From: Michael Eastham <Michael.Eastham@arun.gov.uk>
Sent: 28 April 2021 15:44
To: Planning.Responses <Planning.Responses@arun.gov.uk>
Subject: FW: *EXTERNAL: RE: Water Lane, Angmering - Temporary Sales Cabin (Ref. A/24/21/PL)

Please upload onto Ocella the email below from the applicant confirming the wording of the condition for the flint wall for planning application **A/24/21/PL**.

"Within 3 months of commencement, the length of flint wall which is proposed to be re-built outside the visibility splay, as indicated on Drawing No. P1320 SALES.01 Rev. B - Sales Area Layout shall be built re-using the flint from the existing wall".

Project  
**Land at Water Lane,  
Angmering, West Sussex.**  
Drawing Title  
**Sales Area Layout**

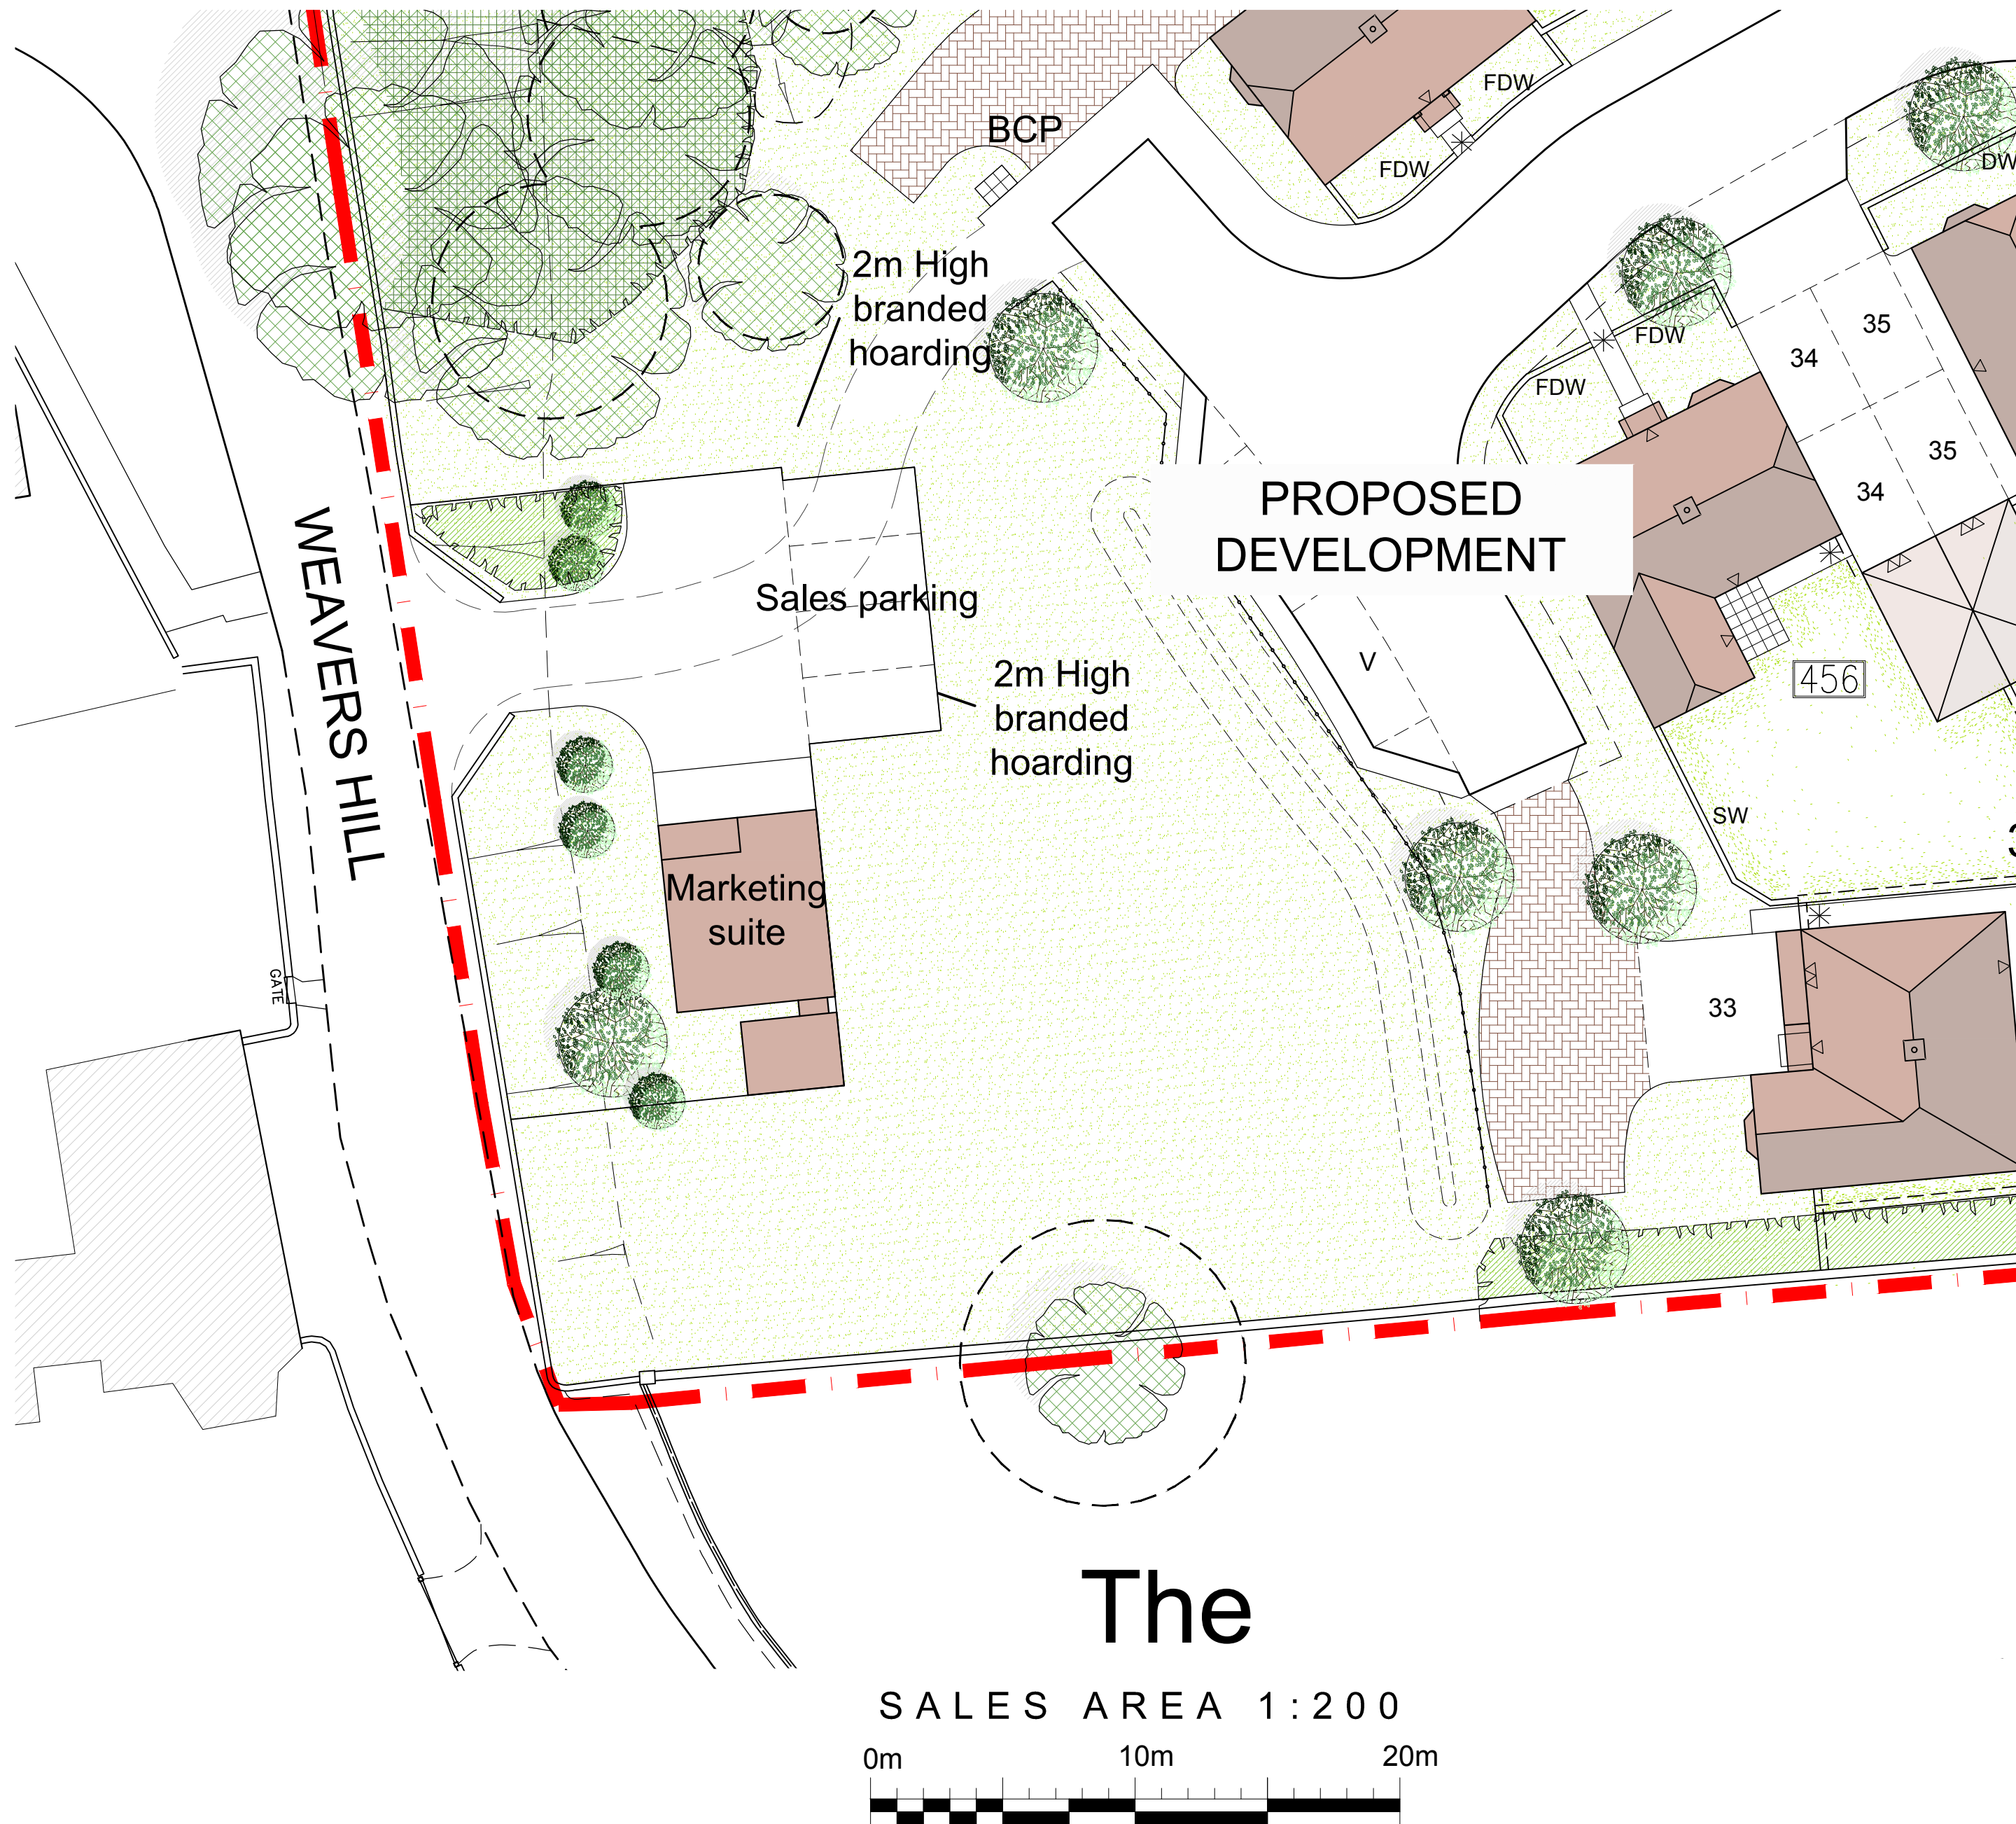
Following discussions with Angmering Parish Council, I have amended the wording of the condition to read:

Condition wording agreed.
